WEST SUSSEX COUNTY COUNCIL CONSULTATION

TO:	Arun District Council FAO: Michael Eastham
FROM:	Tim Townsend - Highways, WSCC
DATE:	30 th May 2018
LOCATION:	Swanbourne Park, Land East of, Roundstone Lane, Angmering, BN16 4AL
SUBJECT:	A/67/18/DOC Application for approval of details reserved by conditions imposed on planning reference A/82/12 relating to condition no. 8 (car parking) & 10 (roads, footway & casual parking areas).
DATE OF SITE VISIT:	30 th May 2018
RECOMMENDATION:	☒ Advice ☐ Objection ☐ Modification ☐ No Objection ☐ More Information ☐ Refusal
S106 CONTRIBUTION TOTAL:	£N/A (secured at outline stage)

This is the WSCC highways and transport response to the above application for approval of details reserved by conditions imposed on planning reference A/82/12 relating to condition no. 8 (car parking) & 10 (roads, footway & casual parking areas).

Drawing Ref
ST-02-12 T

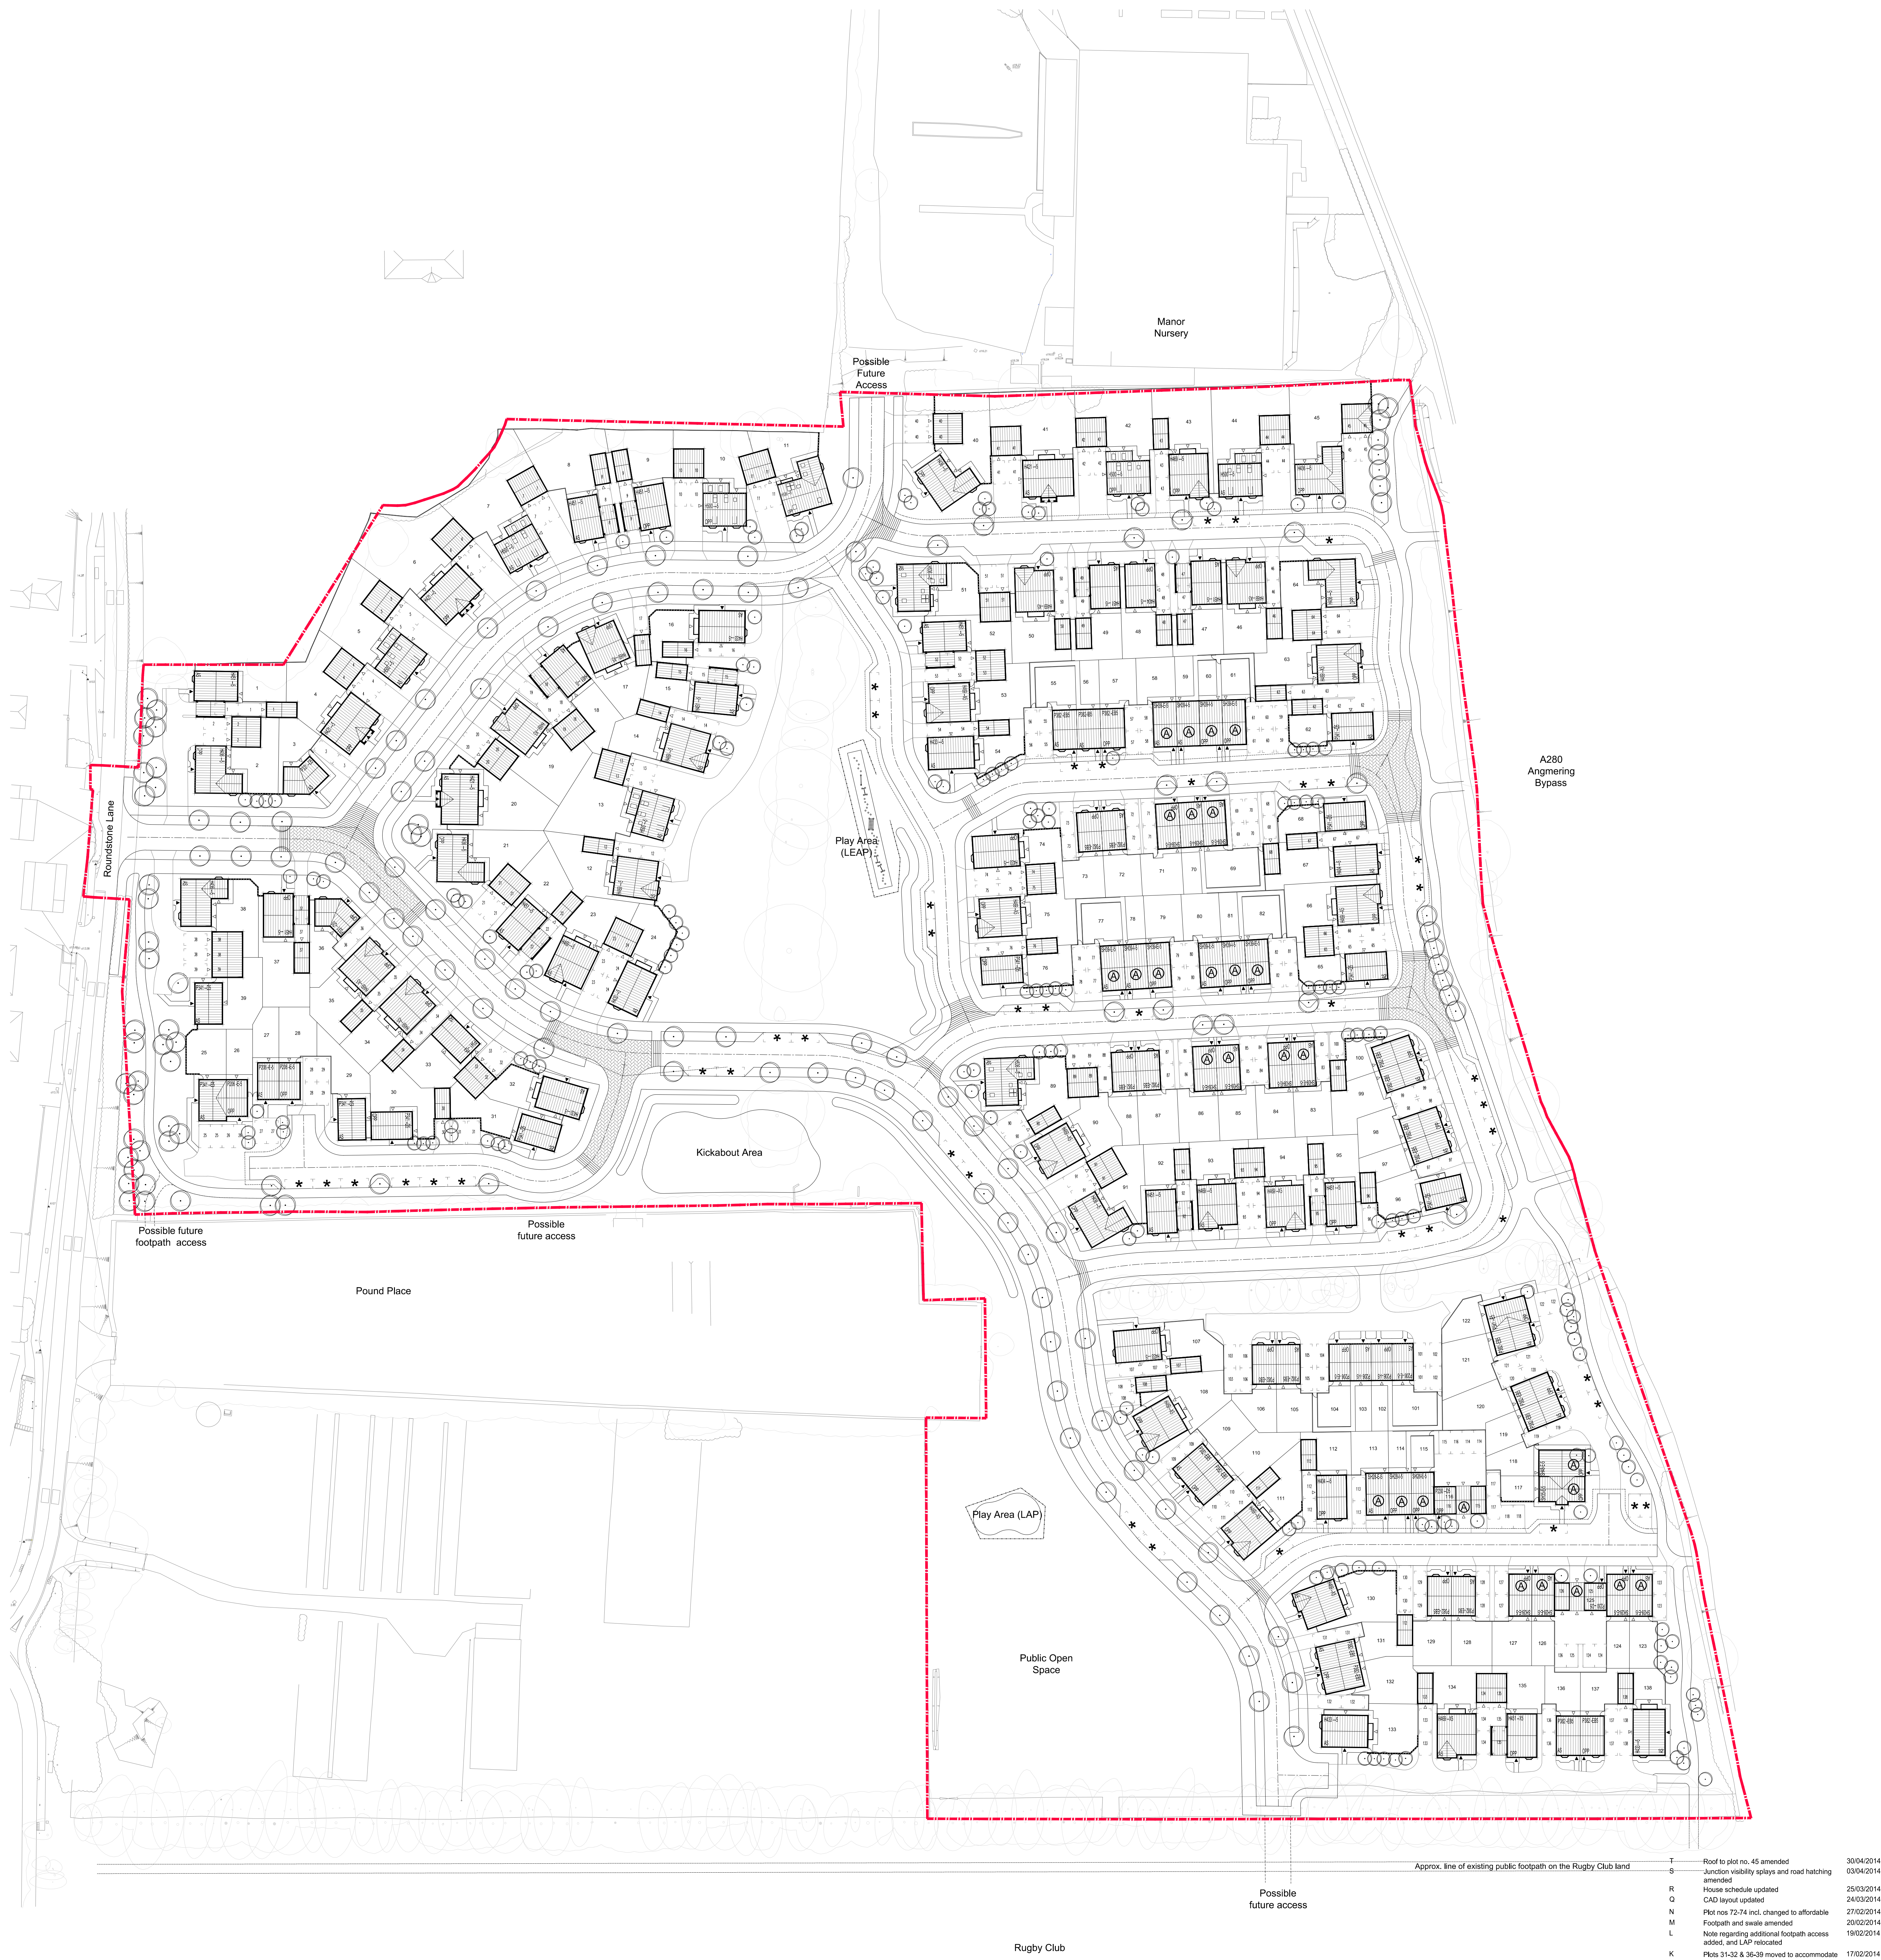
- 1. Condition 8 (car parking)** – Car parking appears to accord with the approved planning layout as shown on Drawing No. ST-02-12 T (dated 10th February 2014).
- 2. Condition 10 (roads, footways and casual parking areas, road specification, surfacing and drainage)** – From a layout perspective, the as-built scheme appears to accord with the approved planning drawings – albeit some is still under construction at the time of writing. However, with regard to *construction details, surfacing and drainage (and specifications thereof)*, this is a matter still under consideration as part of a live Section 38 application. As such, it is not recommended that this condition be fully discharged until such time as all appropriate technical approvals under the Section 38 have been issued.
